FG/16/12

Subject: RE: FORMAL CONSULTATION - FG/16/12/ - COUNTRY FAYRE (ASDA), LITTLEHAMPTON ROAD, FERRING

This development at Country Fayre has already been approved and Asda wish to make some changes to the overall scheme which are identified within this application for a Minor Material Amendment (MMA). One of the changes being that the landscaping/planting will be increased to that of the earlier permission.

Proposed Site Plan

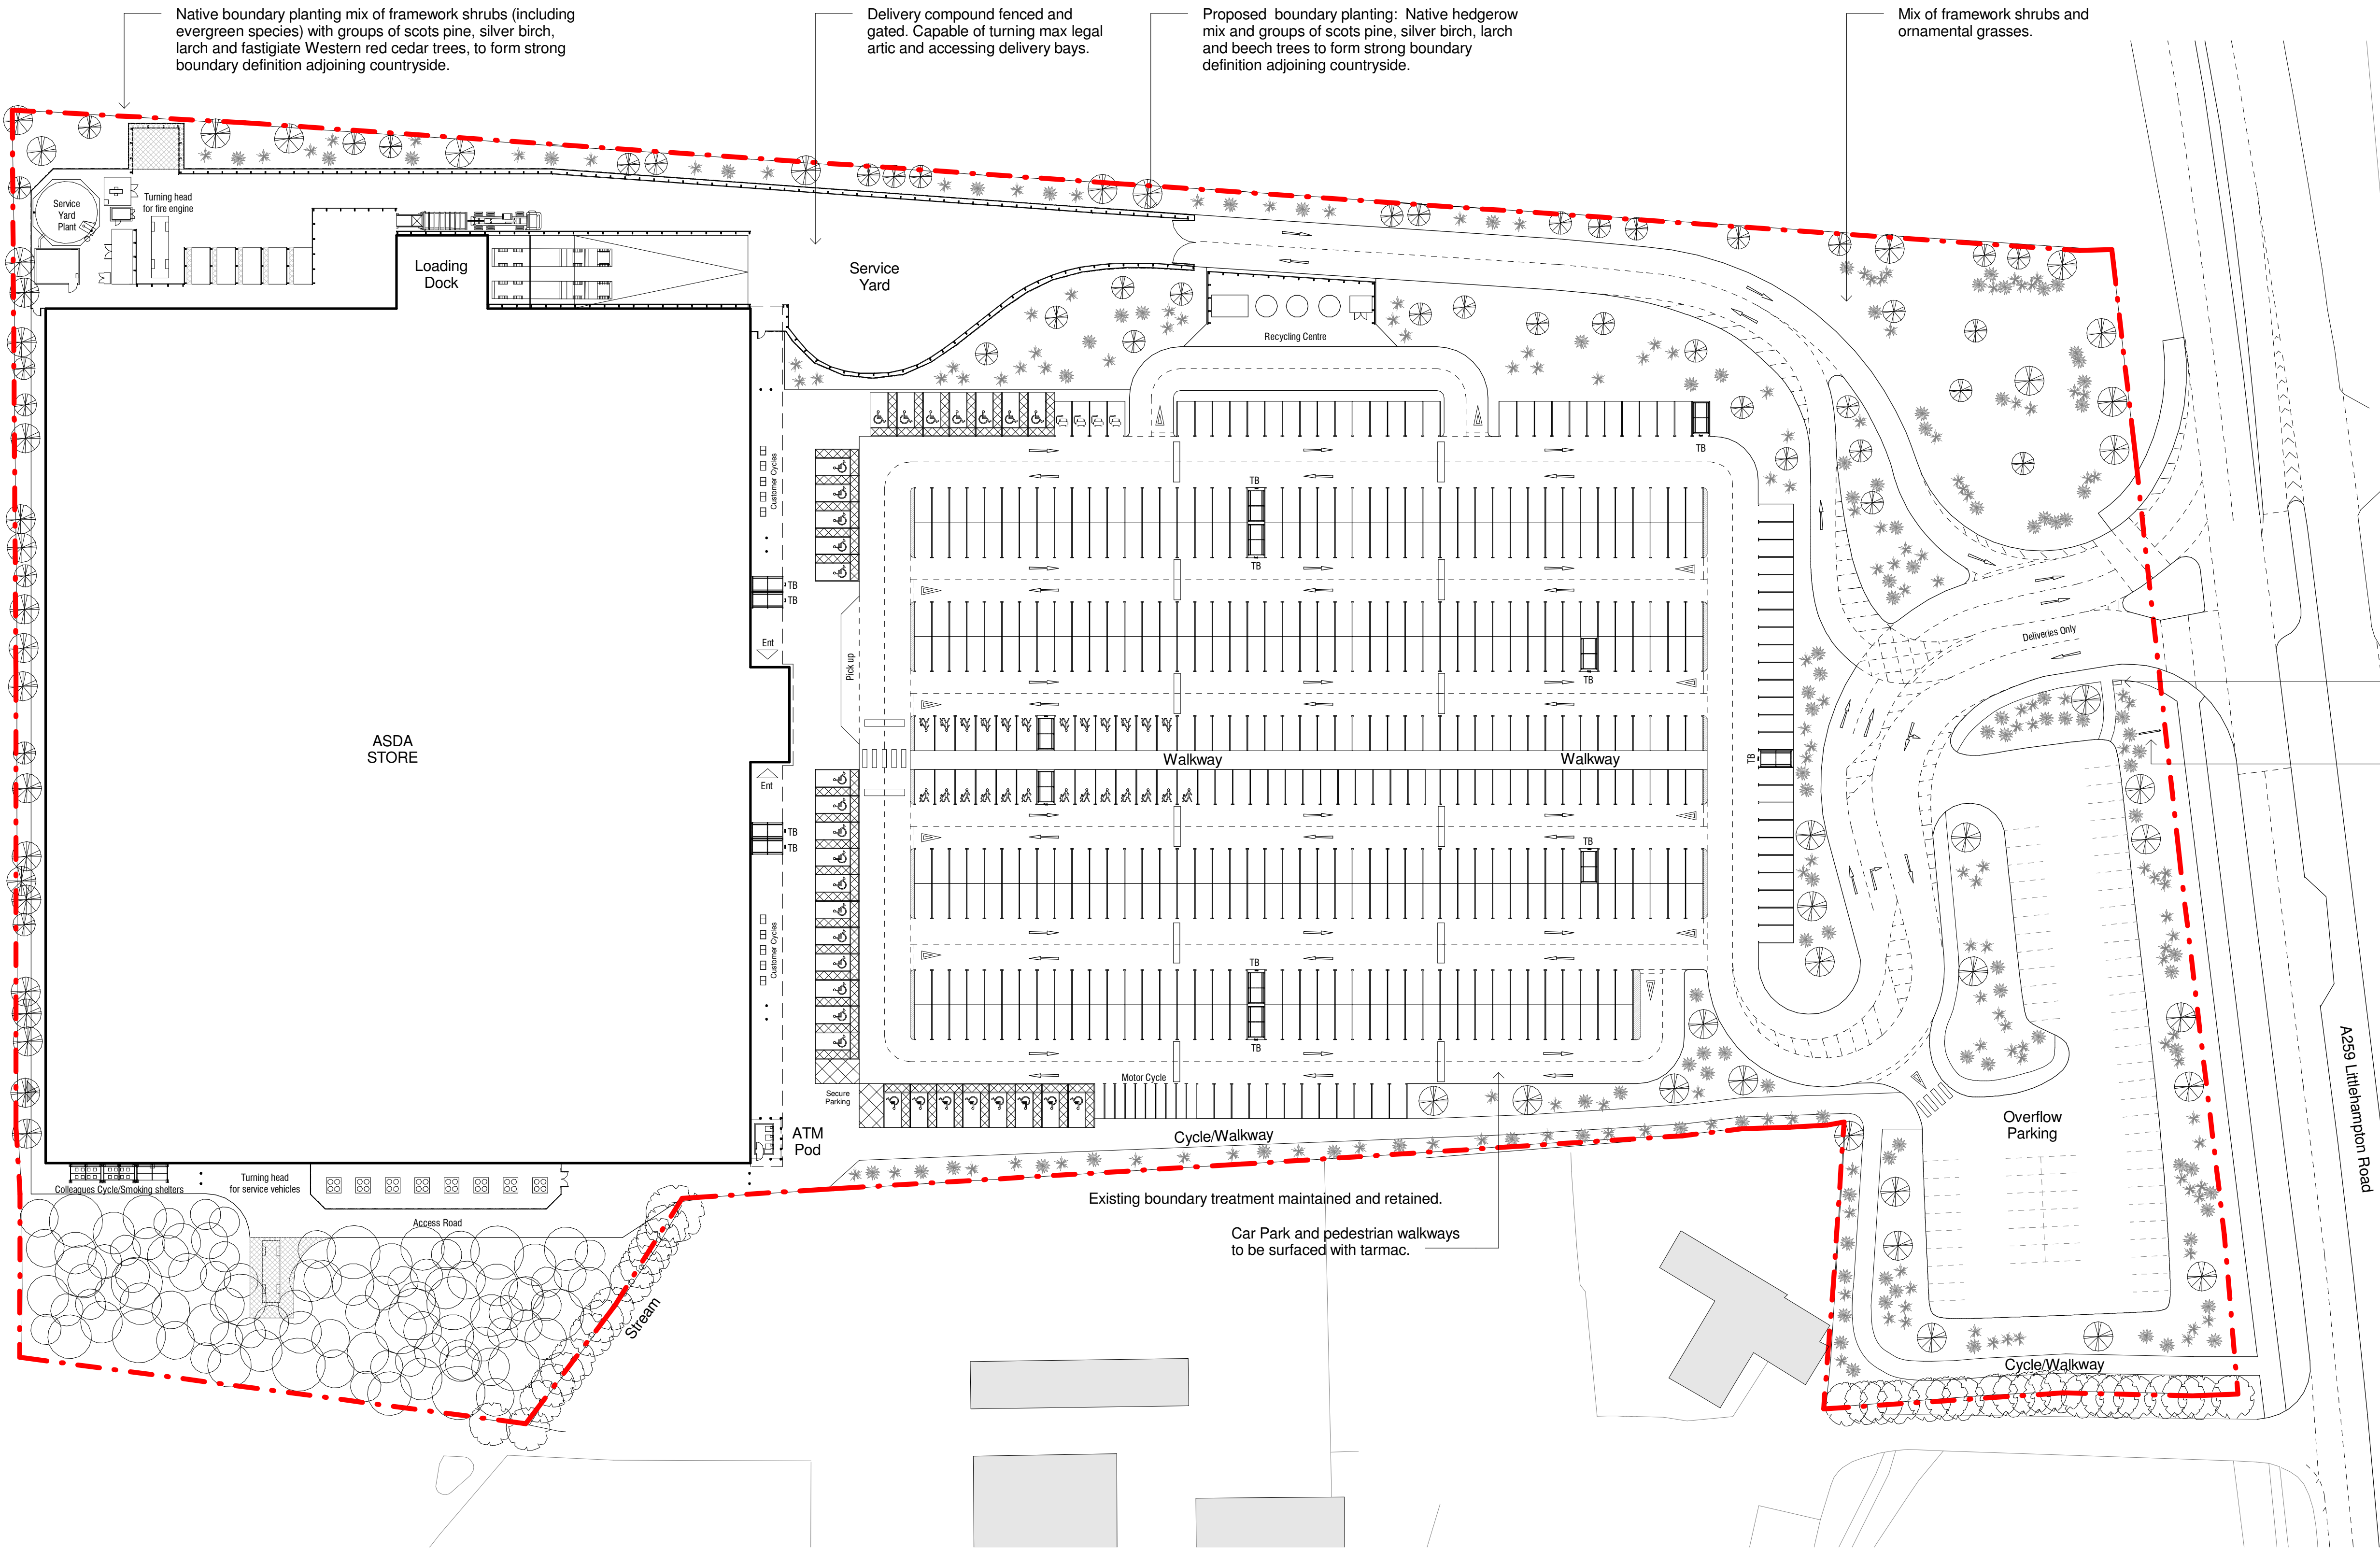
I understand that approval for the ASDA development has been granted. Regarding the planting of trees within the site my comments are based purely from the proposed site plan (scale 1:500), as follows;

The width of the western boundary measures 3.5m. The proposed planting of Scots Pine, Silver Birch and Beech trees will mature and their branches will overhang the access driveway to the loading dock/Service yard. Vehicles using this route will be high sided HGV. Tree planting would need to set at a sufficient distance to reduce the need for drastic pruning work, eliminating the creation of an un-balanced line of trees and increase their life expectancy. It is therefore recommended that the verge is widened to accommodate broad spreading trees or that they are planted at a distance of 0.5m from the boundary to allow at least 3m lateral branch growth without the need for pruning hard back from the driveway. Please note that the planting of Larch is not recommended due to its recent association with the fungal disease Phytophthora. I would suggest provenant and locally sourced English Oak as a possible replacement for Larch.

The overflow car park to the north east is opposite to the planting area (approximately 30x40m) north west and from a visual perspective as viewed from the A259 Littlehampton Road appears unbalanced. It would be appropriate to provide a similar planting scheme/provision for space by halving the overflow car park and supplement the mix of framework shrubs and grasses with trees, suggesting tall, cleared stemmed Scots Pine trees in groups of 3. This would effectively soften and enhance the entrance, adding a natural and prominent landscape feature that would become visible from the highway.

The width of the western boundary and the proposed planting has not changed from the original approved scheme. However, the points regarding the planting and its location will be forwarded to the landscape architect.

Whilst we respect his comments regarding the northern boundary, we have as far as possible tried to maintain the character of the original consent. However, through our discussions we have removed overflow car park 1 to provide a respectful landscape boundary adjacent to the agricultural land to the west and have maintained a suitable provision of overflow parking as per the original application and it is worth noting that the proposed scheme provides a 9m zone of landscaping between the overflow car park and the back of the existing footpath.

The Landscape Architects are currently amending their plans to suit the amended layout and once we have received the completed drawing we will forward you a copy.
